**CITY OF ALBUQUERQUE
PLANNING DEPARTMENT
August 28, 2013
DRB Comments**

PROJECT # 1002498

APPLICATION # 13-70656

RE: Tract 43-C, Town of Atrisco Grant Unit 2

SKETCH PLAT TRACT 43-C, UNIT 2

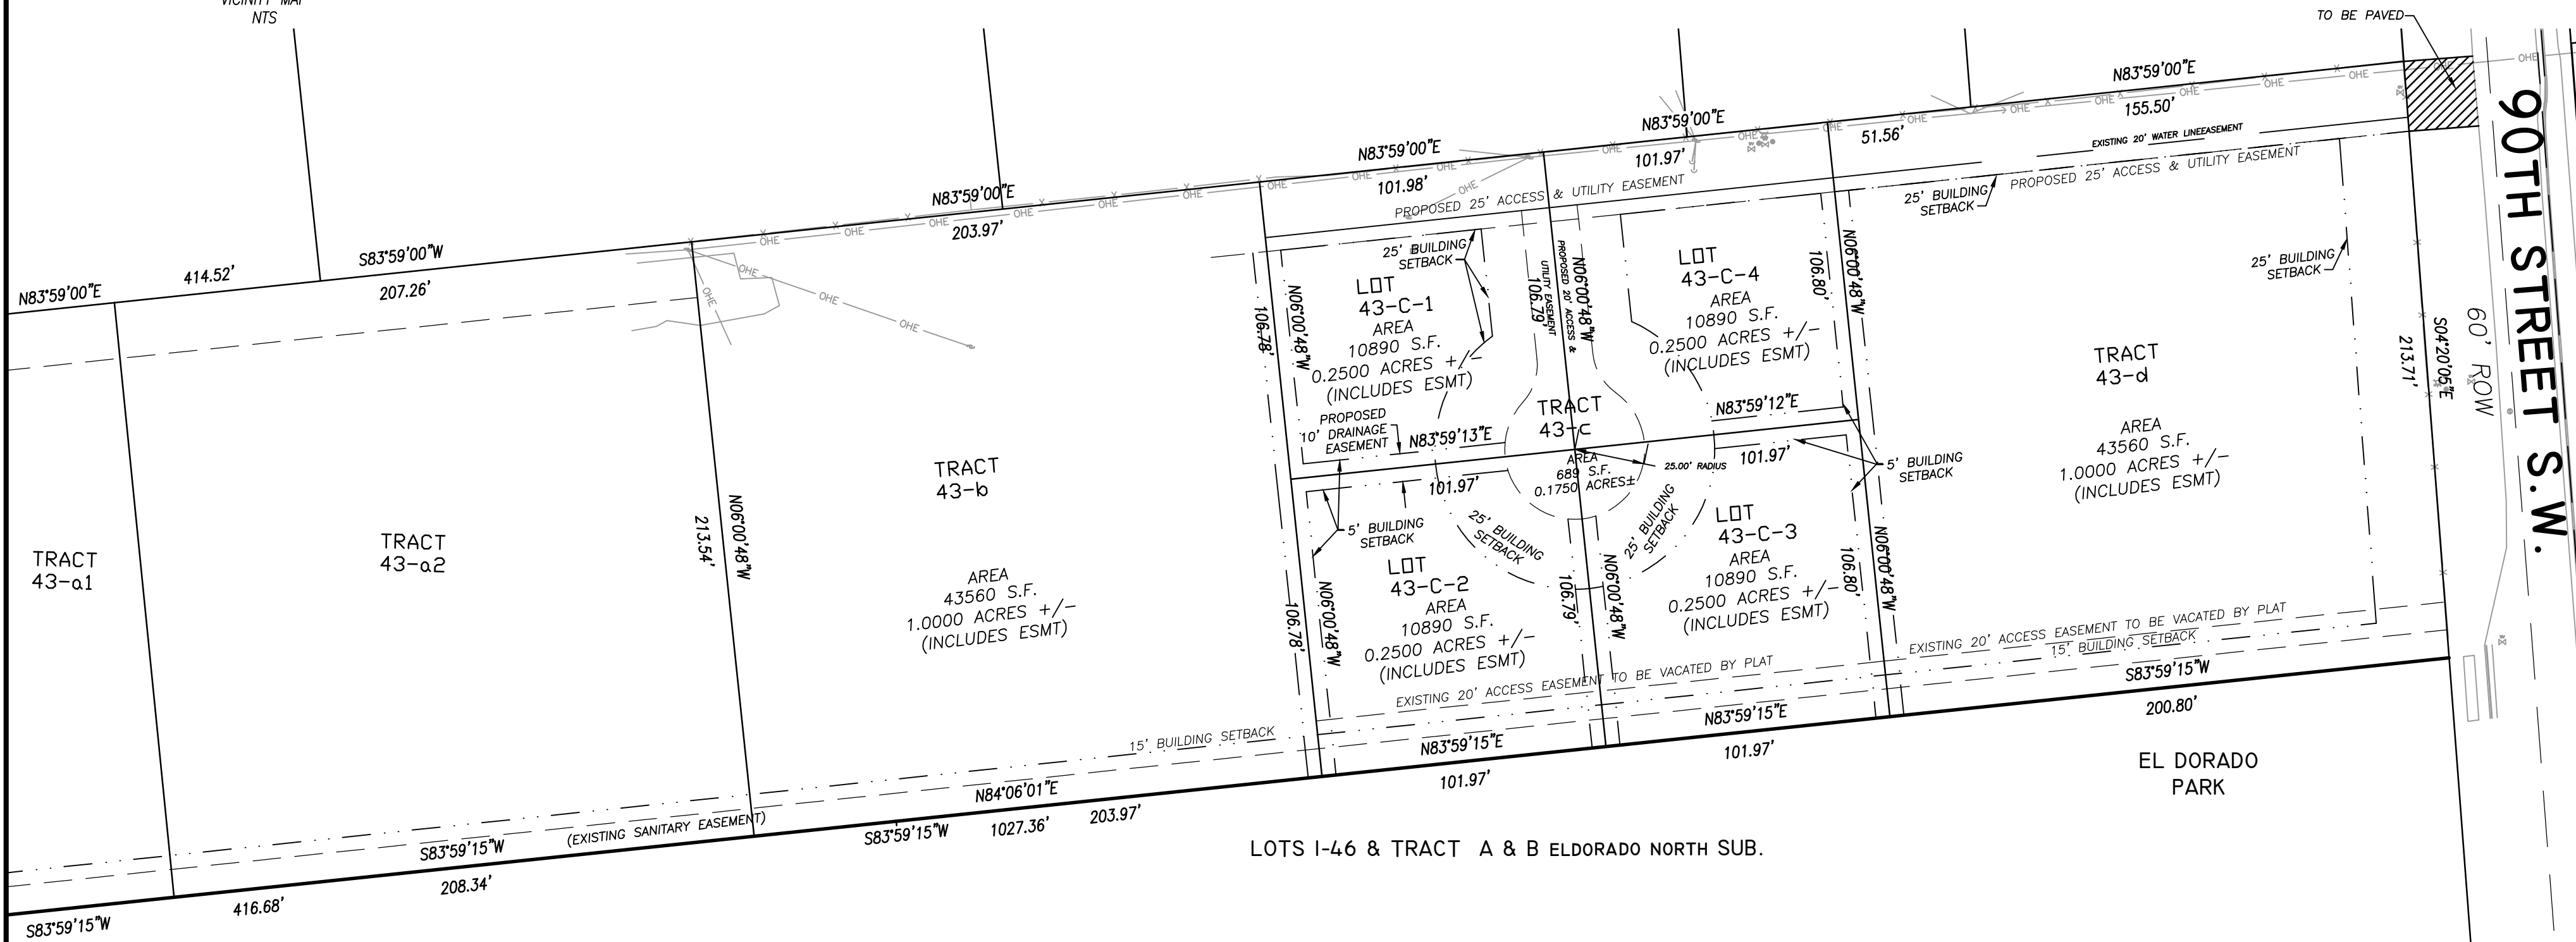
Refer to comments from Transportation Development regarding access requirements – pedestrian access from this proposed subdivision should be provided to Eldorado Park.
